## Lead Local Flood Authority

Date 30 October 2024

### RE: F/14/24/RES – Land at Ford Airfield, Ford, West Sussex

We **object** to this planning application in the absence of an acceptable Drainage Strategy relating to:

Drawing Number:
2205771-D170

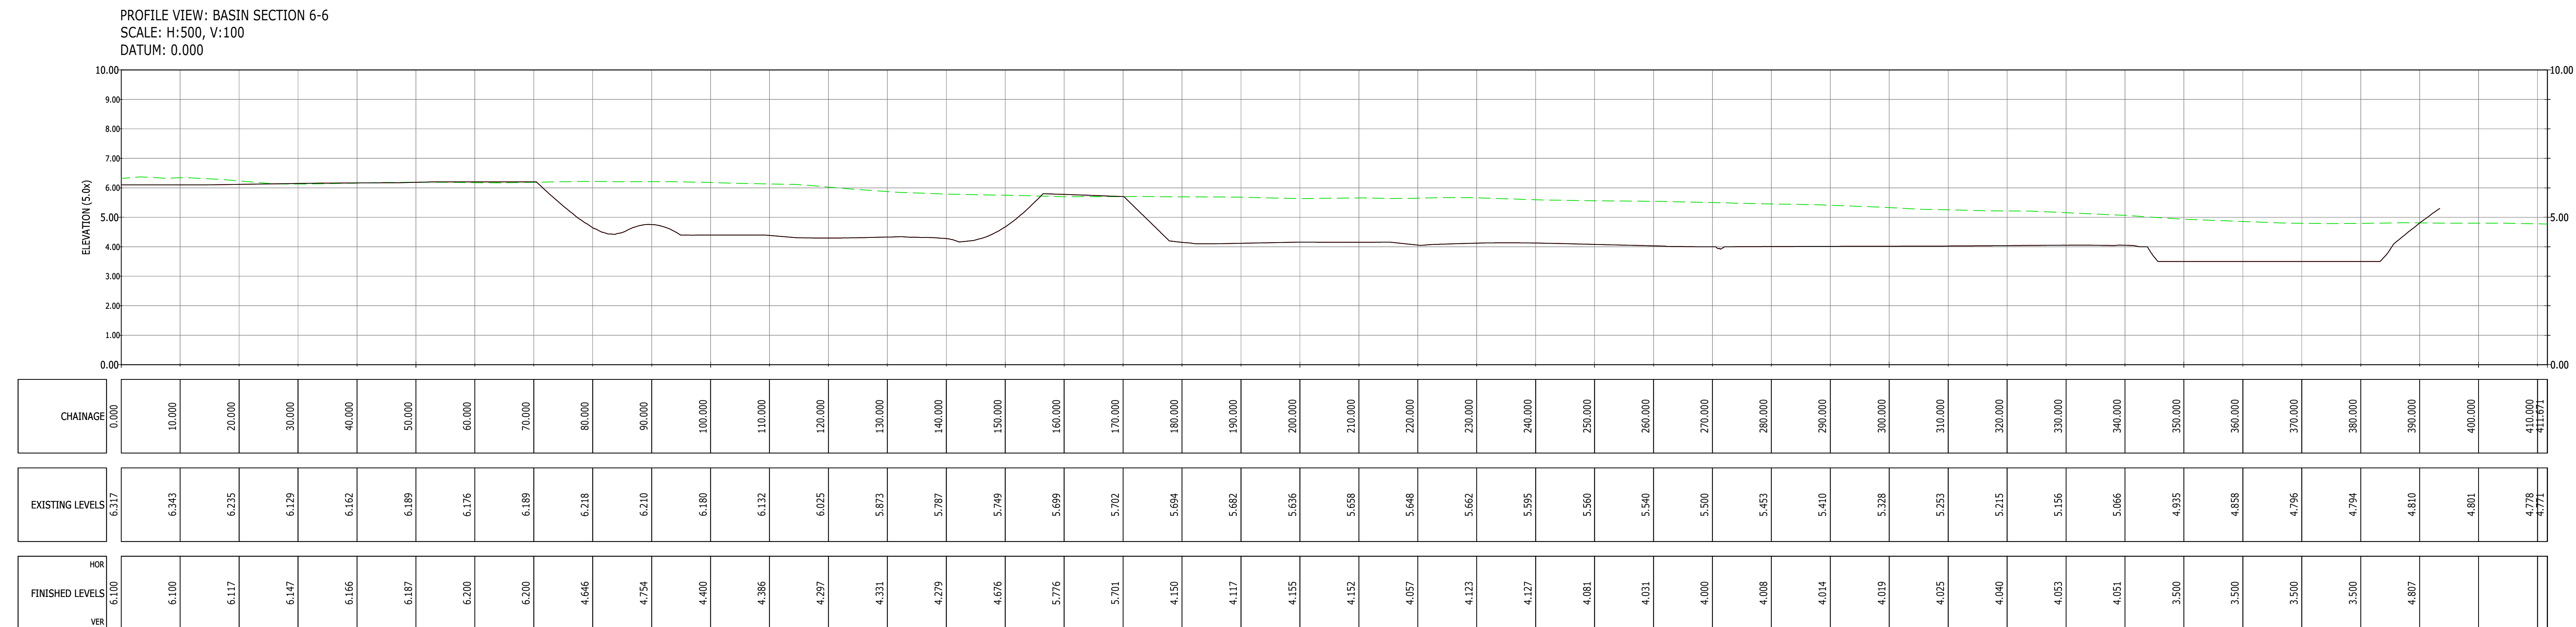
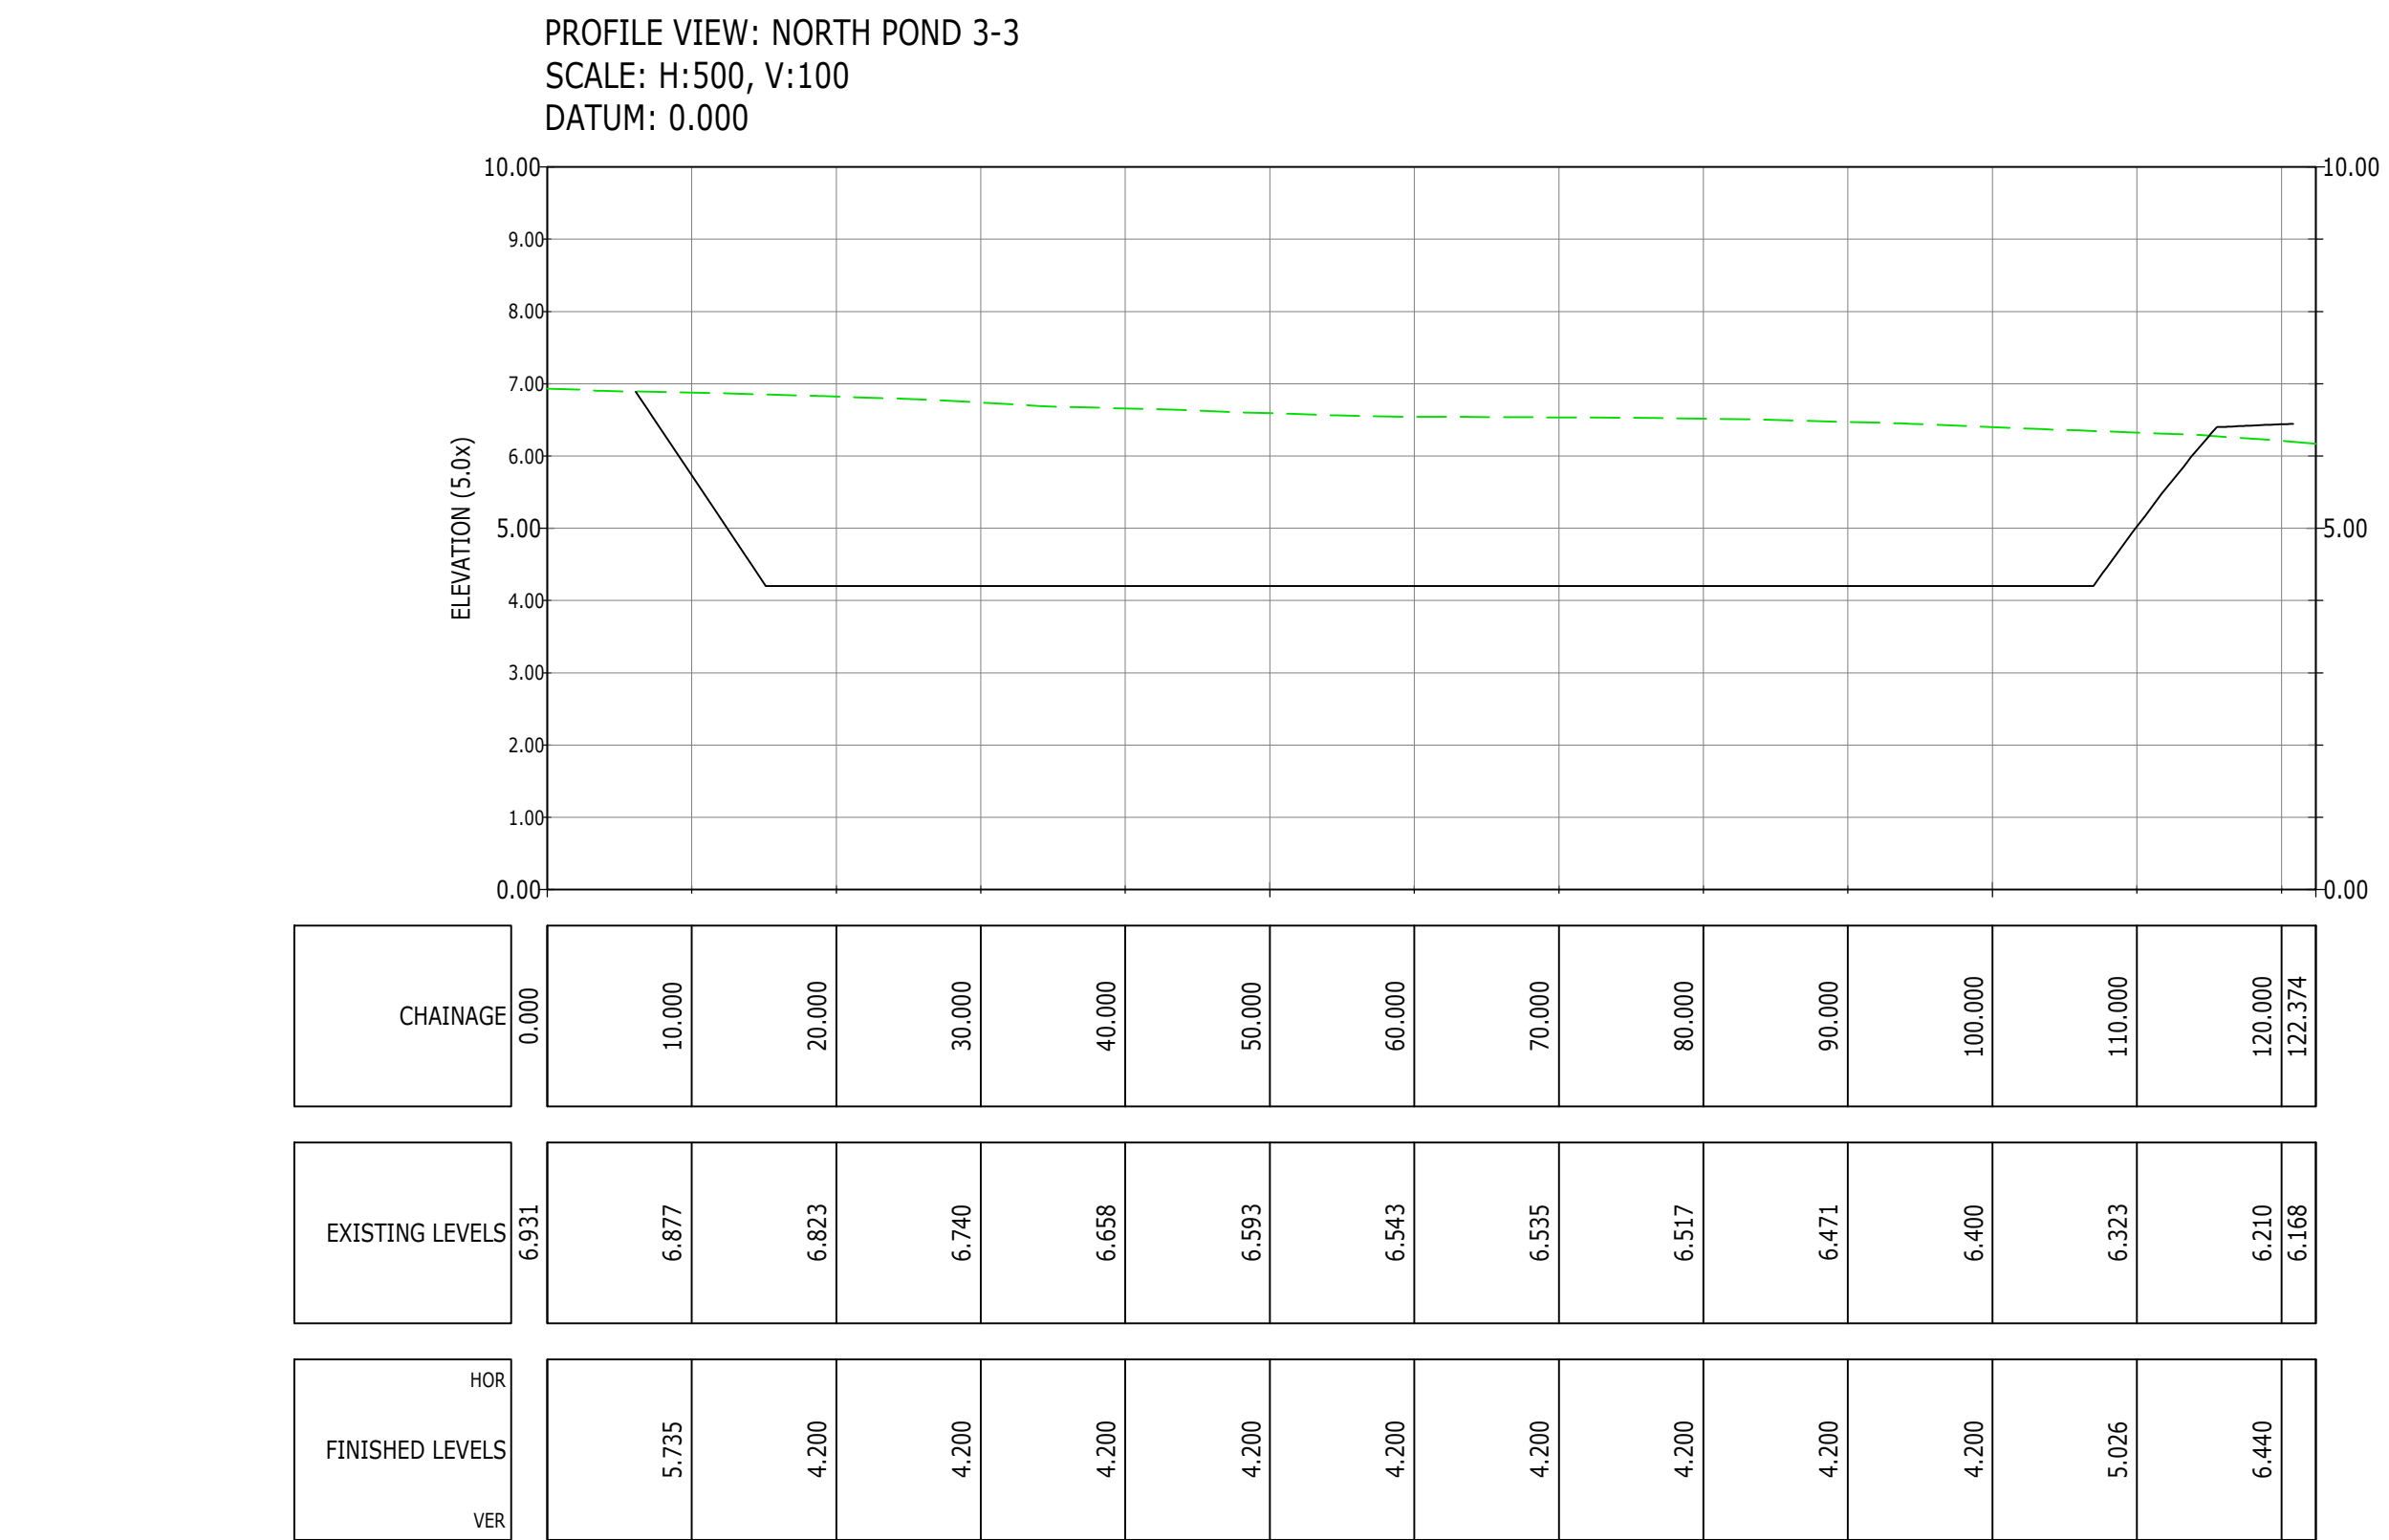
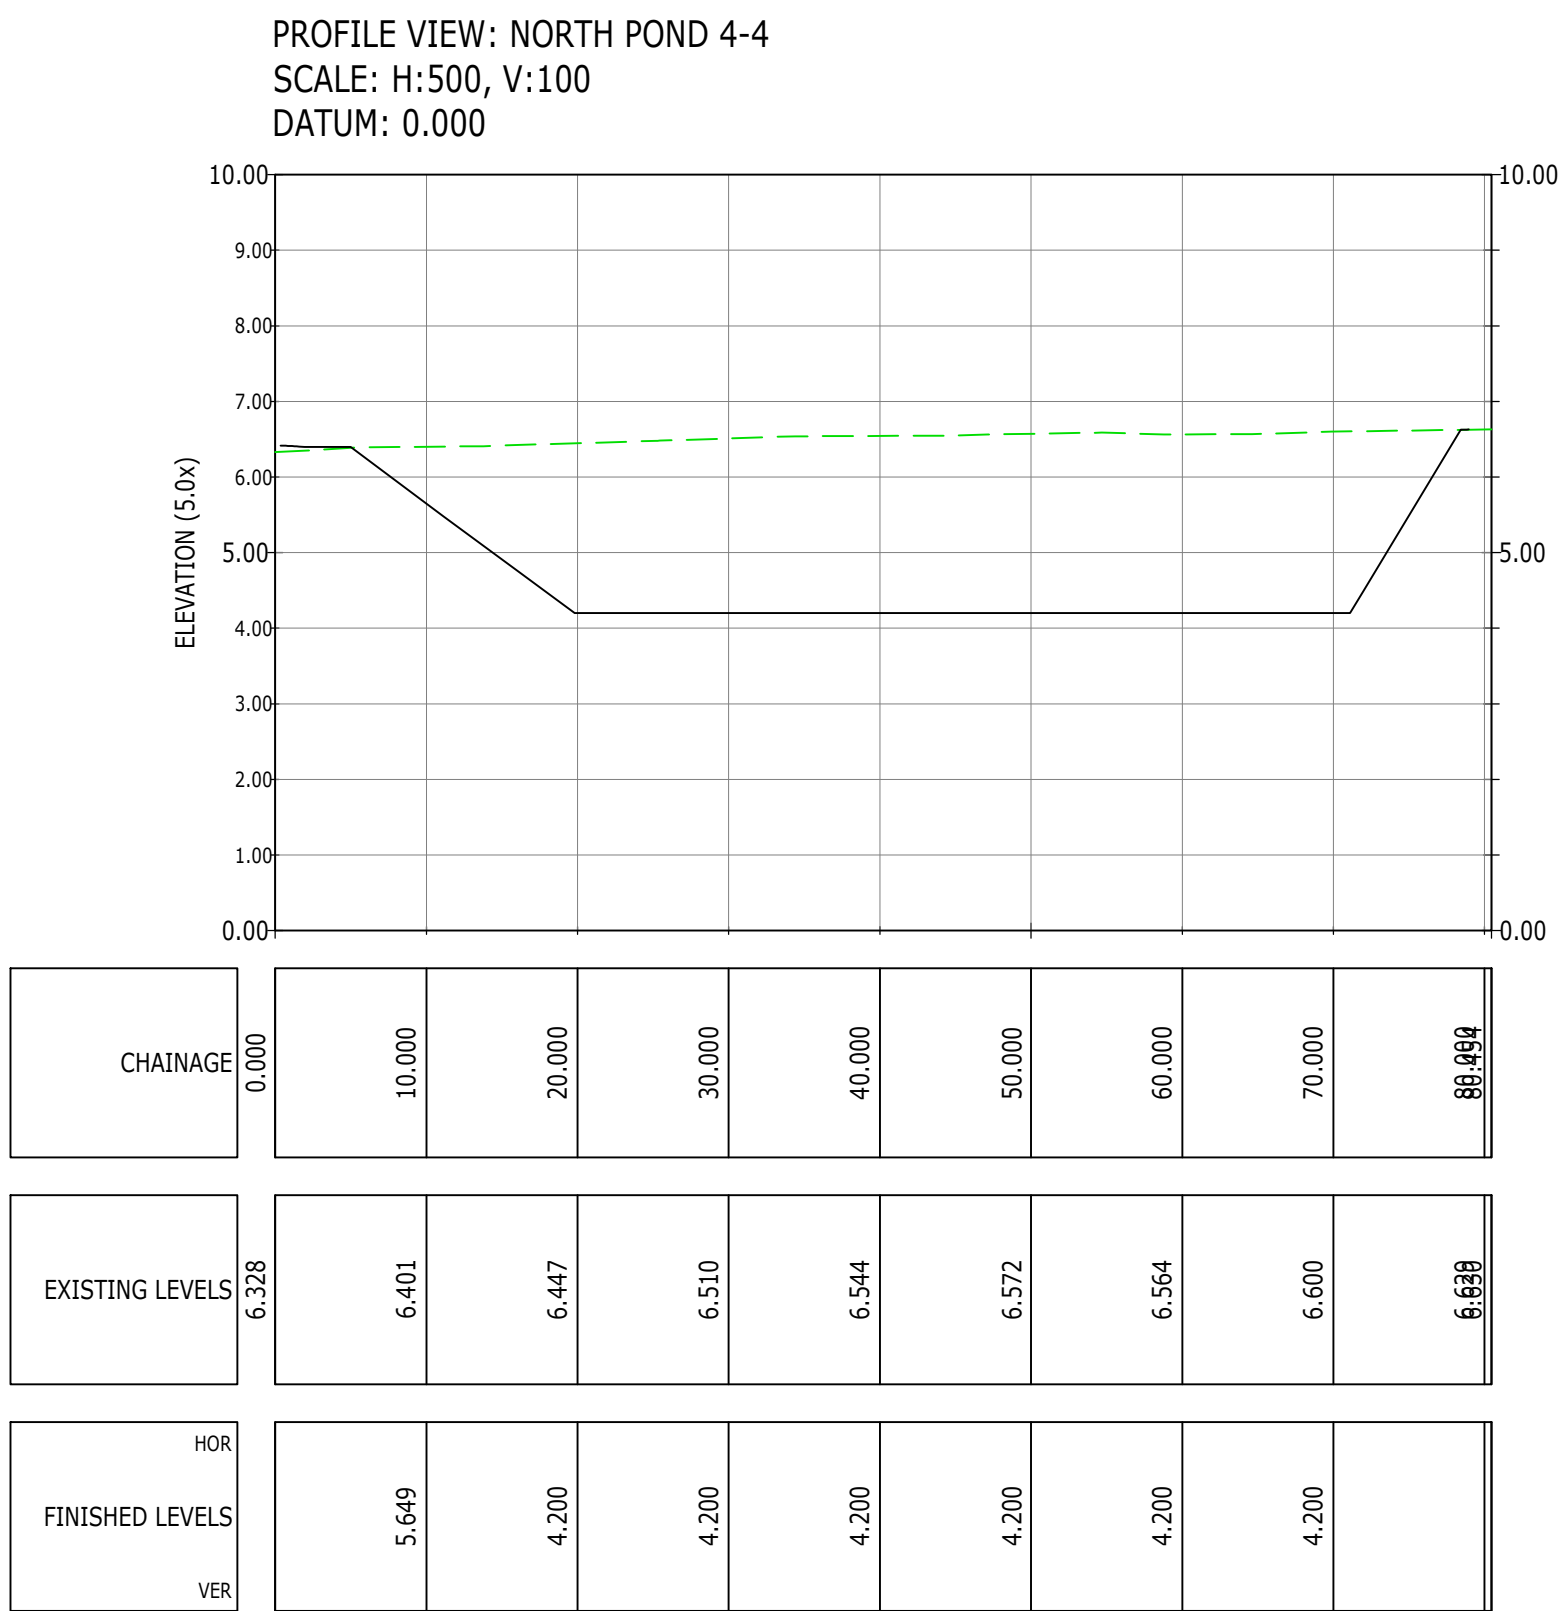
2. The high groundwater levels will also need to be considered in detailed design of attenuation structures. 1m buffer (finished level and water level)

7. Easements 3m from the top of the bank on both sides of any watercourses and the basins are required for maintenance access. Off road parking for maintenance vehicles is also required. Updated plans should reflect these requirements and be sufficiently and clearly annotated.
